RE: Request for Information #2 for File No. SUB21-002 – Angiuli Pacific Res Trust Short Subdivision
4001 West Mercer Way, Mercer Island, WA 98040;
King County Tax Parcel # 362350-0365

Please consider this as a written response to the City of Mercer Island second review comments dated March 17, 2022.

TEAM response

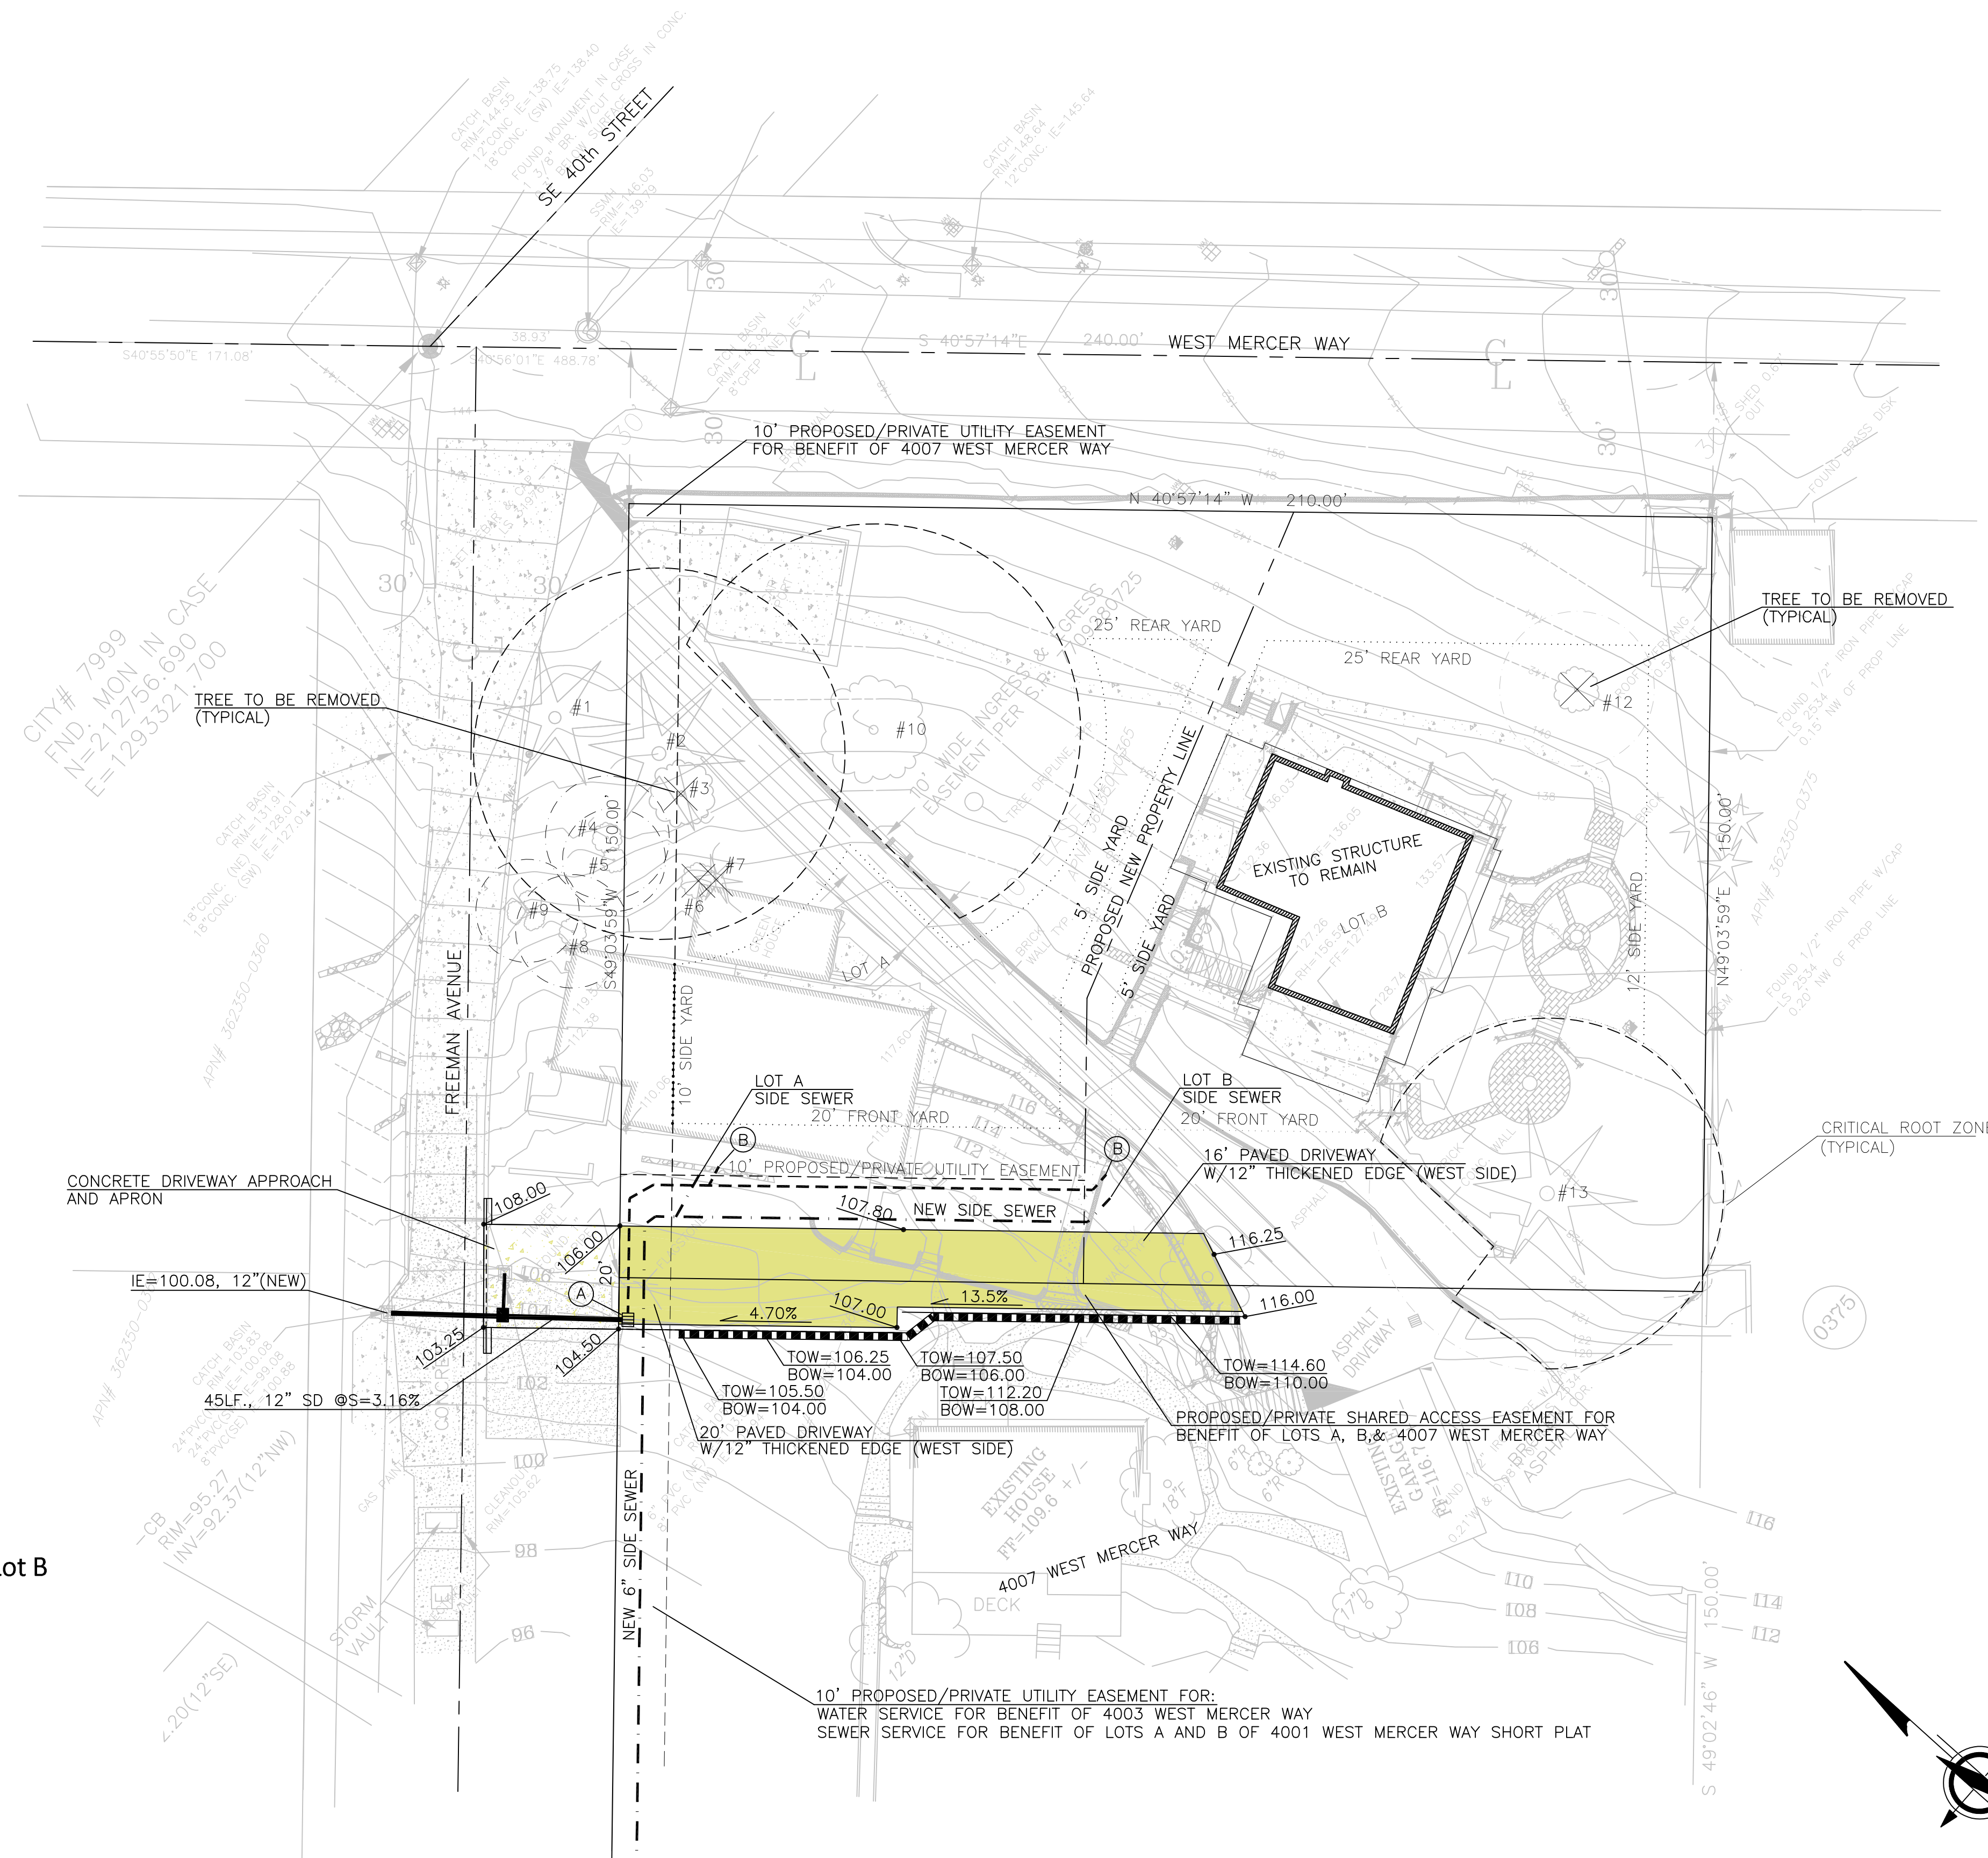
- c. Page 7 of 9: there is a note that states the following "existing impervious surfaces to be removed under separate demo permit, typical." The applicant has decided to apply for the demo permit after preliminary plat review. A condition of approval will be that the applicant shall update the lot coverage, hardscape, and impervious surface calculations for the final plat application. **Noted, we understand this will be a condition of approval.**
